From: Christopher Smith
Sent: Wed, 13 Jan 2021 14:35:48 +0000
To: Holly Chapman
Cc: PLServices;Peter Ord
Subject: 20/01636/FUL - Walter Gidney Pavilion Fountain Lane Soham

Proposal: Demolition of part of existing community hall, replacement with a purpose built rear extension

Location: Walter Gidney Pavilion Fountain Lane Soham Ely

Reference: 20/01636/FUL

Client	SOHAM TOWN COUNCIL	First Issue	19/03/20
Project	SOHAM PAVILION PHASE II	Scale	1:100 A1
Title	PROPOSED UTILITY / RENEWABLE TECHNOLOGY STRATEGY	Author	TCG
		Checked	JNS
		Approved	JNS

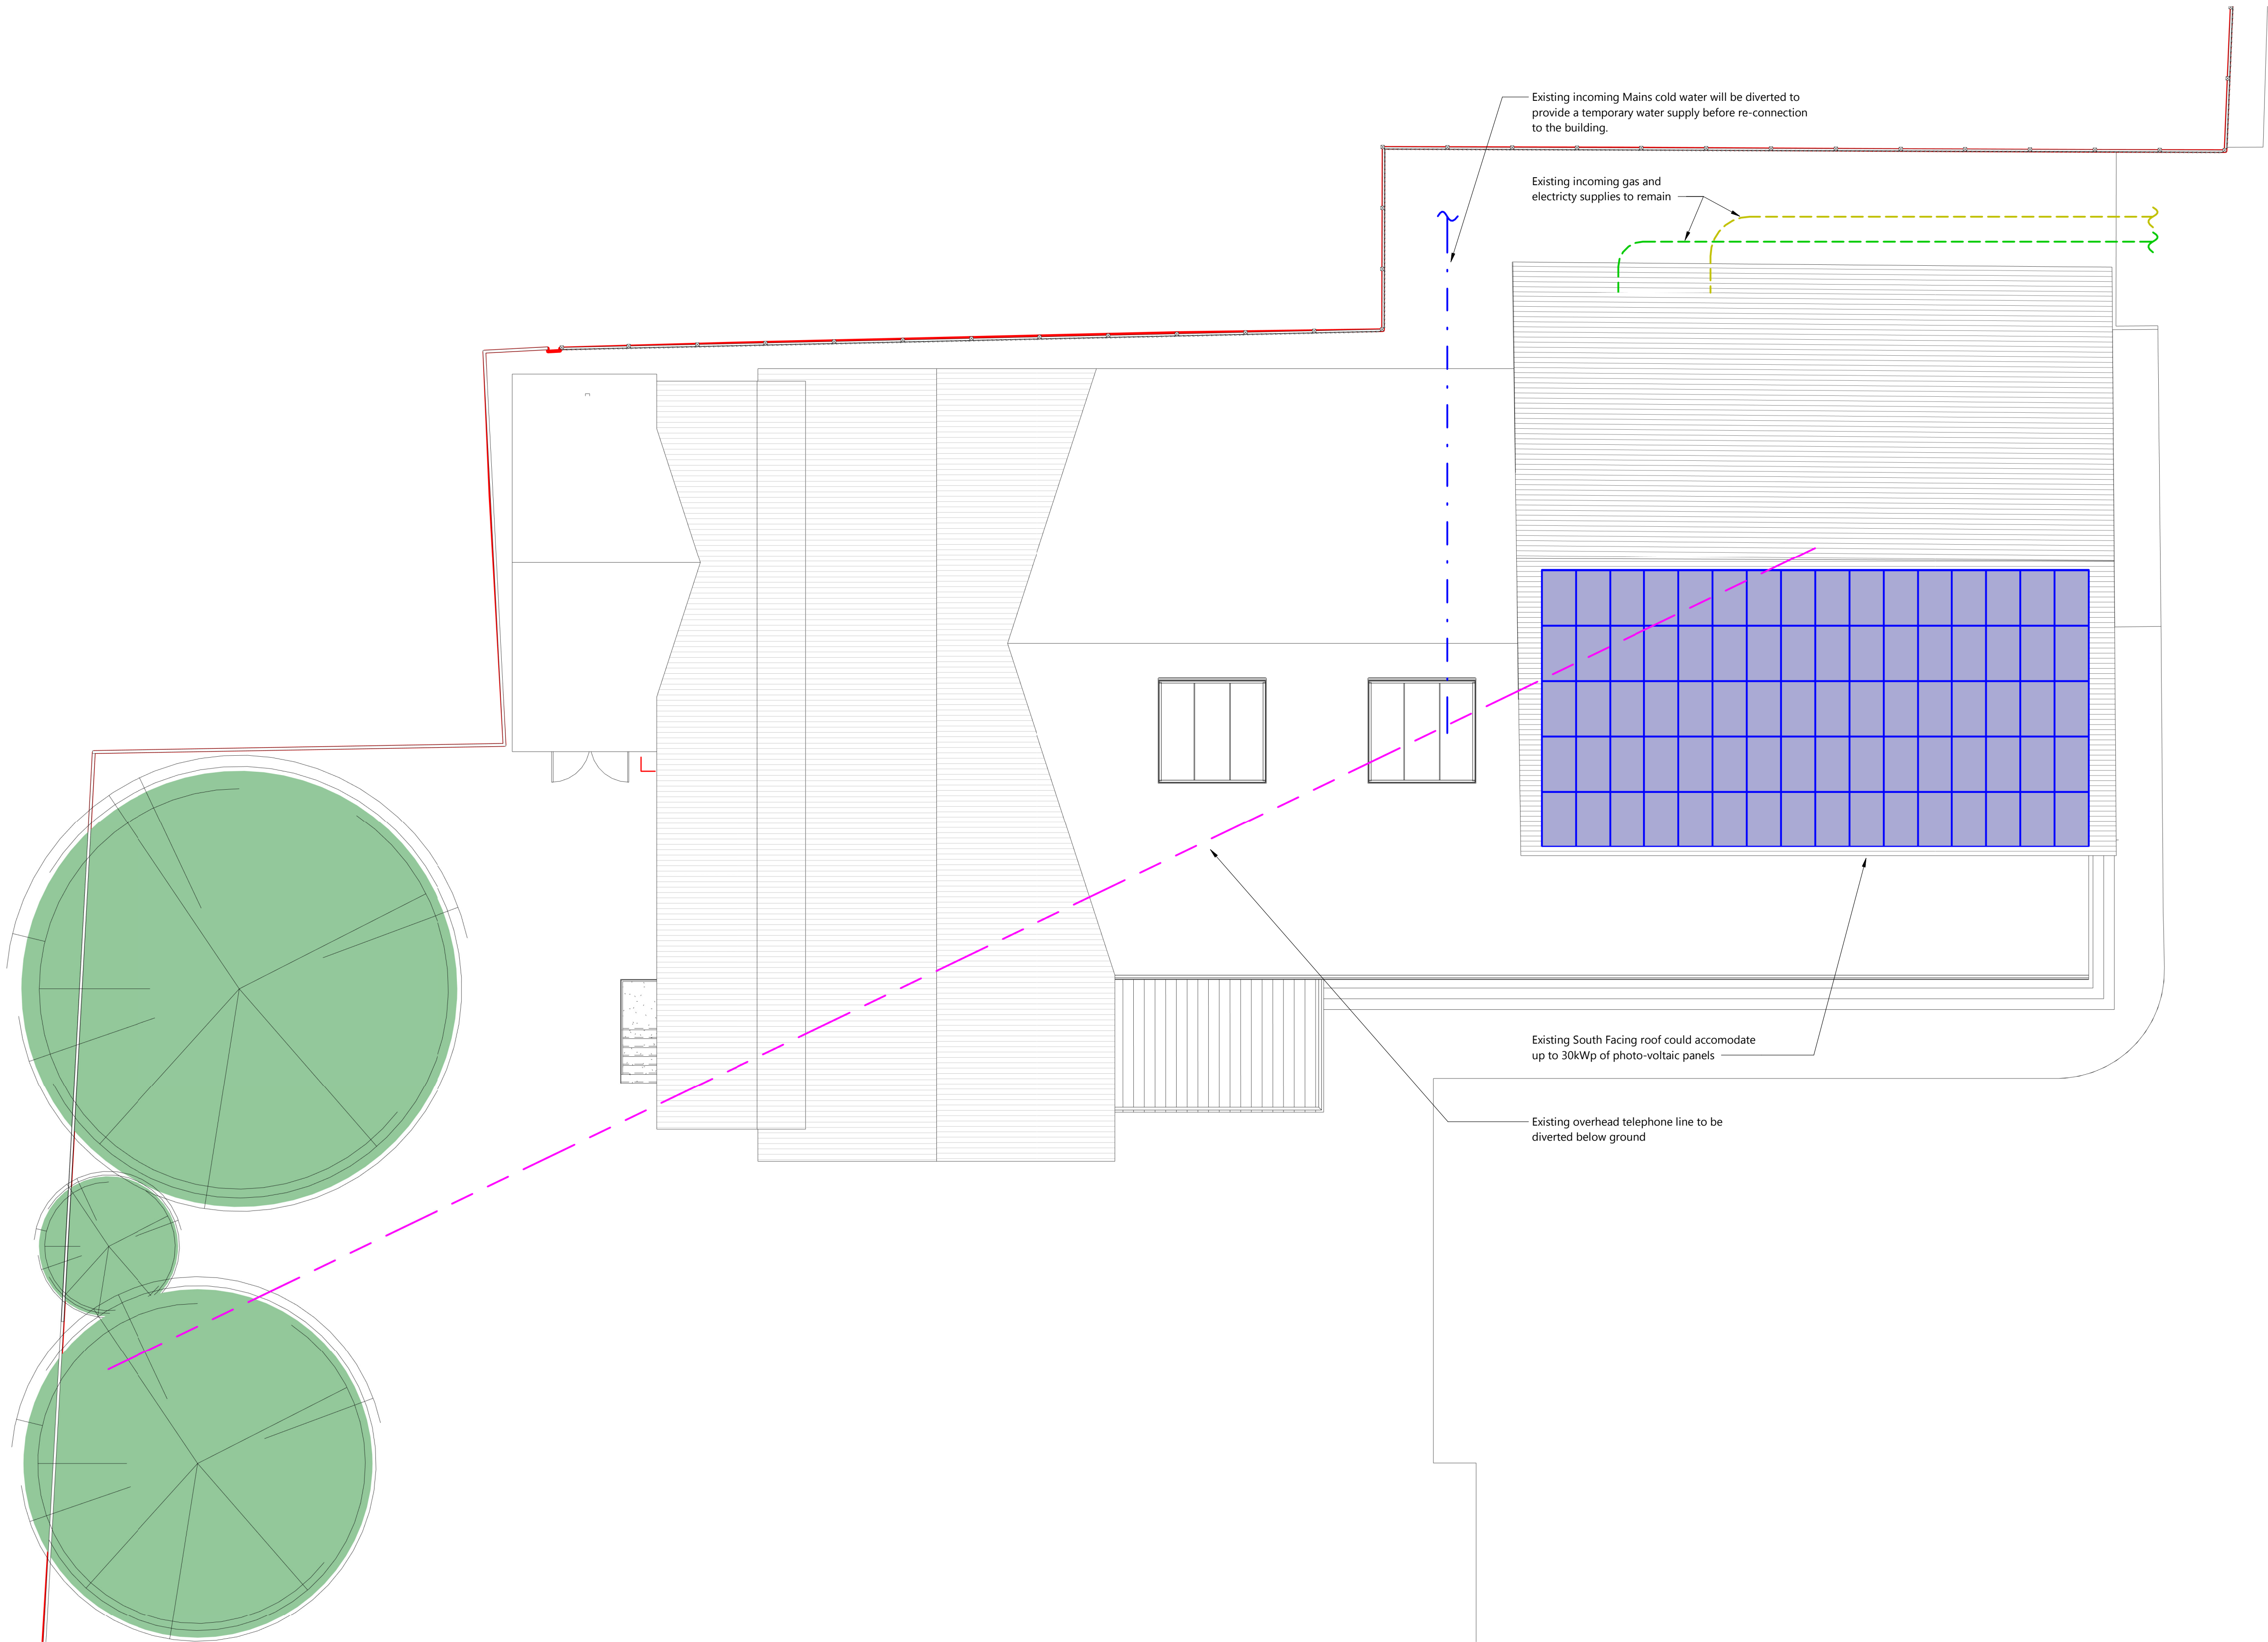
The Stage 2 Report discusses the use of Air Source Heat Pumps. ASHPs are becoming more common but they have also been known to generate noise complaints. I wouldn't wish to raise any objections but I would like to know the proposed locations of the pumps and the model specifications (including acoustic information). I'm happy for this to be a condition to discharge later on as I wouldn't expect this information to be known at this time.
